**Proposed sand mine in Bobs Farm. Application Number SSD-6395.**

#### Say No to Sand Mining In Bobs Farm Community Action Group Response

Figure 2-3: Local Topography

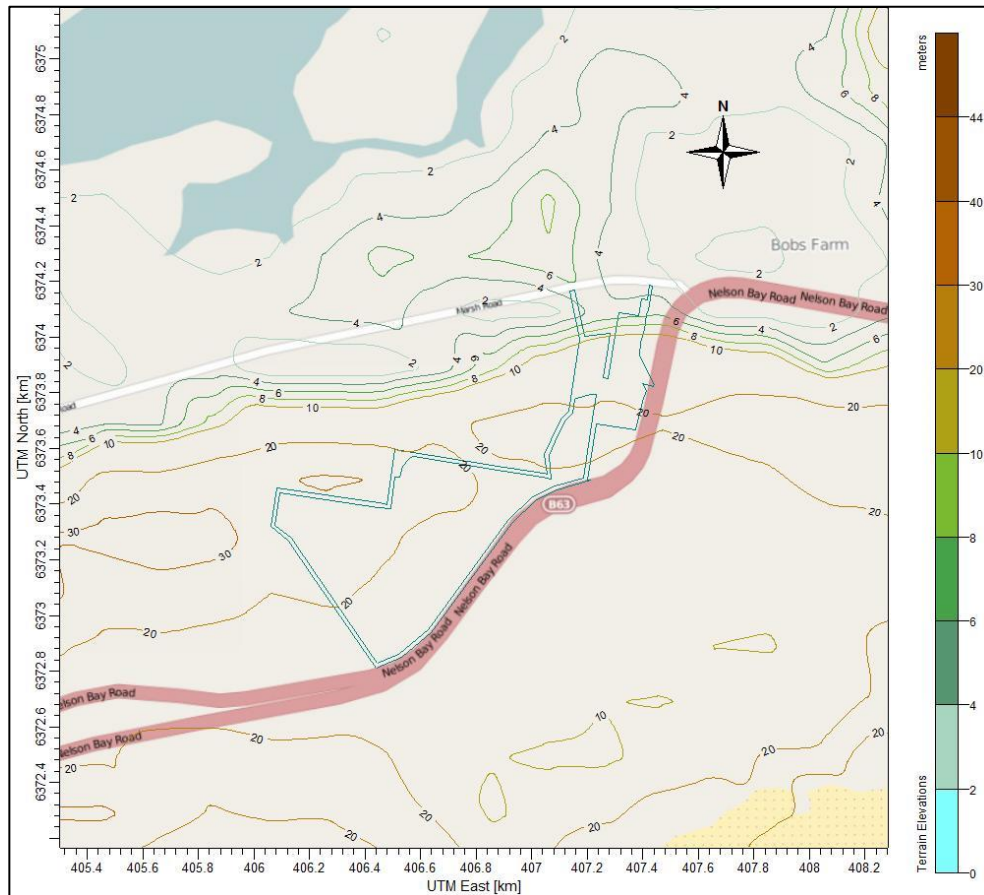
- Note that in the Air Quality Report Annex L cannot accurately identify the site. "2.1 Site Location: The Bobs Farm site deposit is situated on the northern end of the Stockton Bight Dunal system". It is not part of this dunal system. "2.6 Local Topography: The Project is situated is approximately 2 km from Nelson Bay." Bobs Farm is not located at this distance. These statements demonstrate that the expert engaged to carry out his work has no local knowledge. If the report cannot accurately identify where the site is located, how can any of the information be seen to be accurate?

Figure 5-1: PM₁₀ Concentrations at Newcastle [DECCW, 2013]

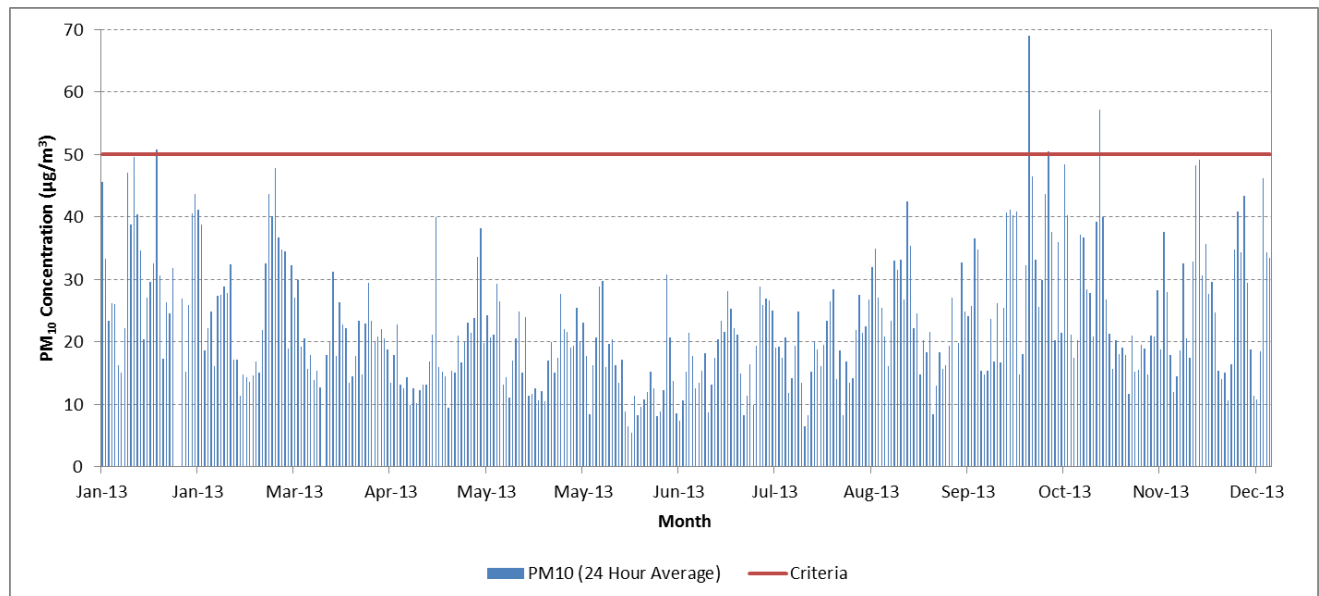
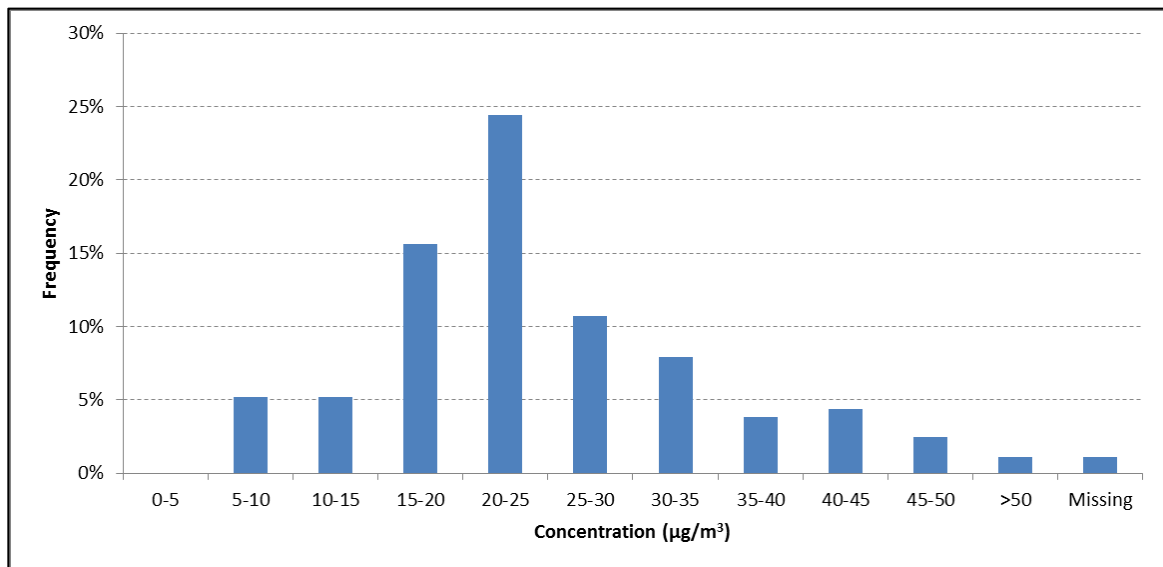
- Note that Section 12.5.1 Ambient Particulate Monitoring within the EIS has used figures obtained from 29km away from the site. Since the available data is from 2013 and additional Sand Mining operations have commenced in the surrounding areas to the proposed site, these figures are inadequate at best, and should be considered obsolete.
